ISSUES SPECIFIC HEARING: 11 MARCH 2025
Submission by Pam Spreckley on behalf of HALT

HEALTH & SAFETY ISSUES RELATING TO BESS'S (AND SOLAR PANELS)

Environmental Statement Figure 11.5: Noise Contour Map Night-time

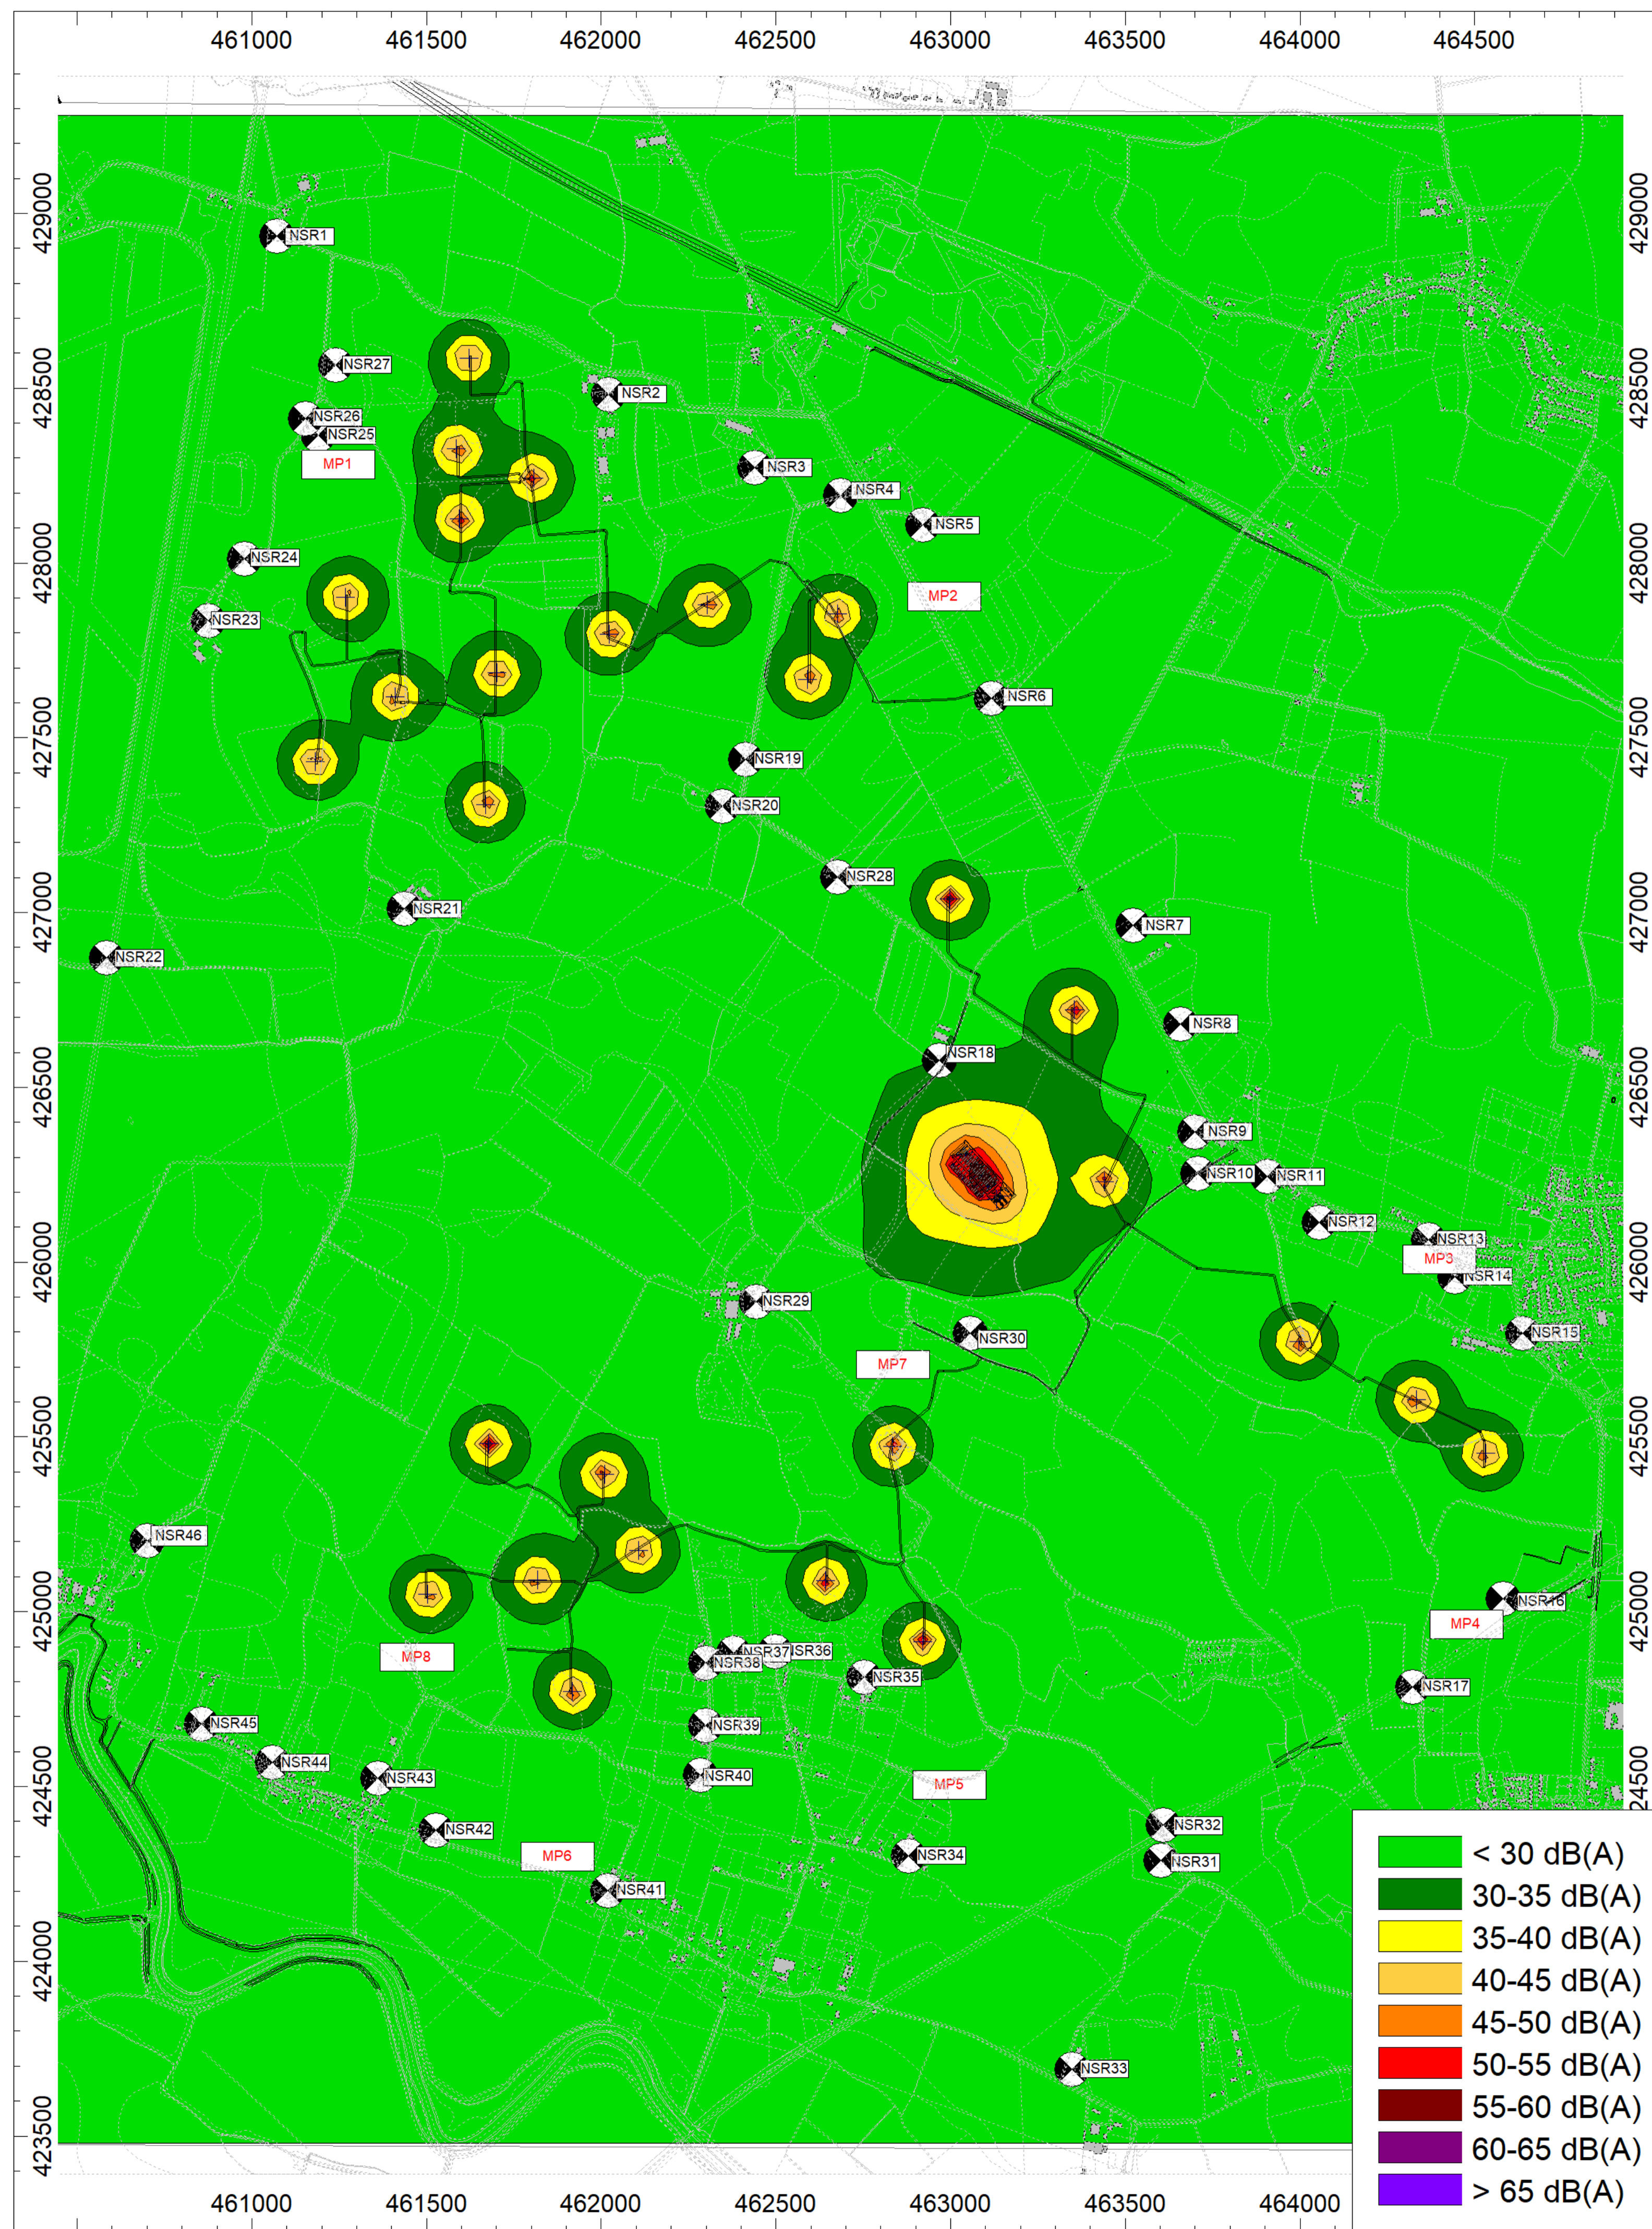
- i. Surely it would be the case that the cumulative impact of up to 76 units will lead to a noise nuisance, especially when it is expected that all fans over the entire facility could operate simultaneously over the 24 hour period and mindful of the prevailing winds towards residences and the village.

- v. The Applicant did not accept or was unaware that the fans across the entire site can operate simultaneously, therefore this scenario will not have been included in the noise assessment exercise. Please would it be possible for this to be done, to ensure a more accurate picture is achieved and for this to be presented to environmental health for an opinion?
- vi. The Applicant has obviously assumed that their assessments will be accurate and have therefore provided no assurance that remedial measures will be undertaken, should this not be the case. Please can we request that such assurance is given and that the Applicant is asked to specify the methods of noise control that will be considered if this is necessary?
